**WELWYN HATFIELD COUNCIL – DEVELOPMENT CONTROL**  
**DELEGATED REPORT**

<b>APPLICATION No:</b>	<b>N6/2012/1913/AD</b>
------------------------	------------------------

The application seeks advert consent for the erection of five externally illuminated signs. The signs would measure approximately 750mm tall and would be located approximately 3.4 metres above ground level. The letters would be flush with the face panel and there would be a total of six lights above the signage to provide illumination. The two projecting signs would have external illumination above the signs.

TITLE	Restaurant
CLIENT	The Real China
PROJECT ADDRESS	1 Howardsgate, Melwyn Garden City, AL8 6AL
DRAWING NUMBER	E-0-02
ISSUE/DATE	23 Oct 2012
SCALE	1:100
DRAWING BY	Yanf Yao

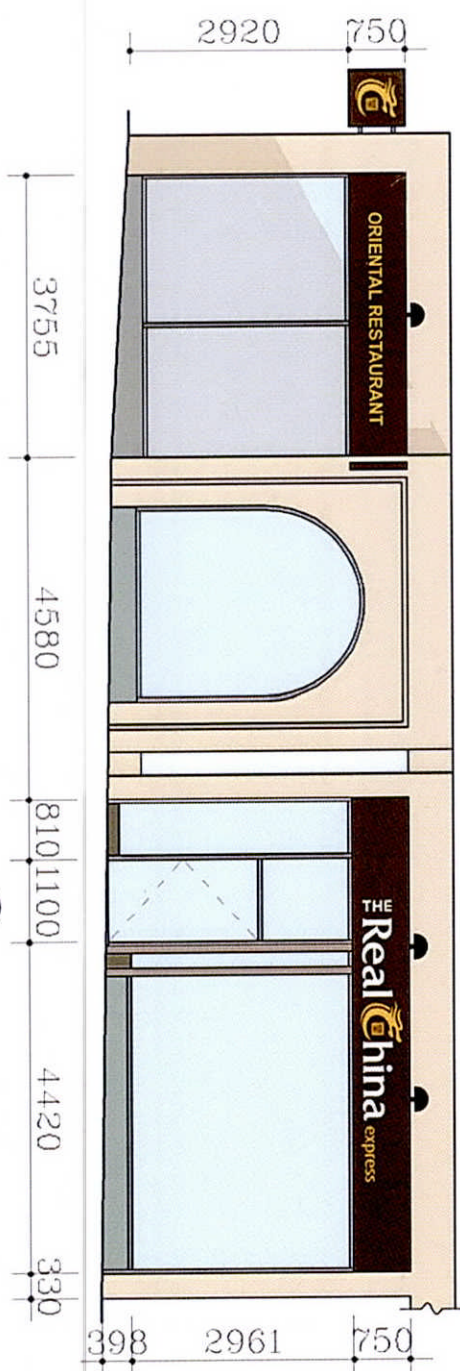
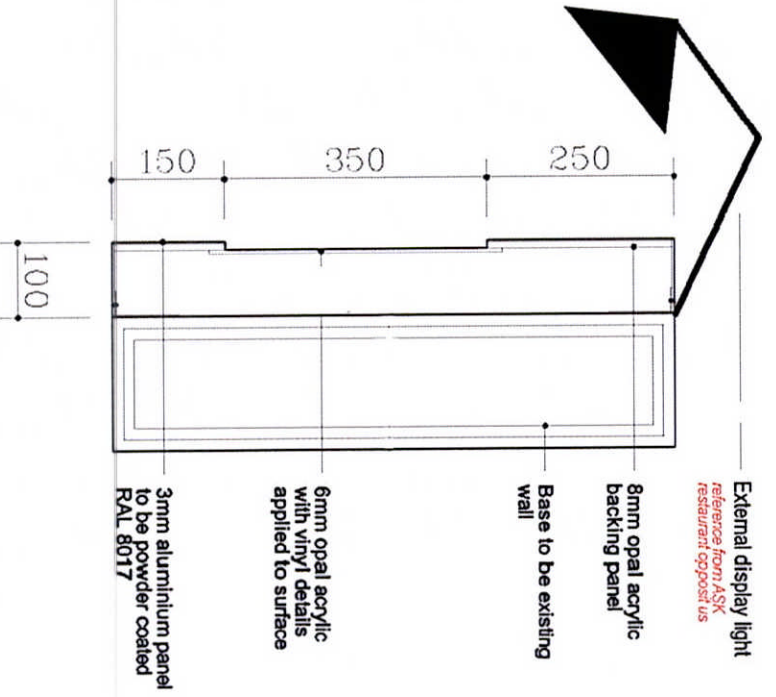
The signs would project a similar distance as other signs and would be positioned over the existing openings and insets of the building, which would relate to the architectural features of the building. In addition to this, it is considered that the proposed signage would differ from that proposed in the previously refused scheme as it would use external illumination and would also not involve the insertion of signage in the window of the premises. Whilst these are not entirely significant changes, they have the effect of improving the overall visual appearance of the signage and the stonework surround is not affected.

However, the plans submitted do not provide clear details of the proposed external lighting units and it is considered that in the event of approval a condition should be attached to request that these details are submitted to and approved by the local planning authority prior to the commencement of development. Subject to the inclusion of this condition in the event of approval the proposal is considered to sufficiently overcome the previous reason for the refusal [N6/2012/379/AD] and would comply with the NPPF and District Plan Policies GBSP2, D1, and D2.

9. Within one month of the date of this consent full details of the proposed external lighting that will be used to illuminate the fascia signage hereby approved shall be submitted to and approved in writing by the local planning authority. The

installation of the lighting shall be carried out within two months of the date of approval of the details and shall be permanently maintained in accordance with the approved details, unless otherwise agreed in writing by the local planning authority.

Reason: The plans do not show sufficient details of the lighting and this is required in order to ensure that the proposed design of the lighting sufficiently maintains the character and appearance of the property and surrounding conservation area in accordance with the NPPF and policies GBSP2, D1 and D2 of the Welwyn Hatfield District Plan 2005.
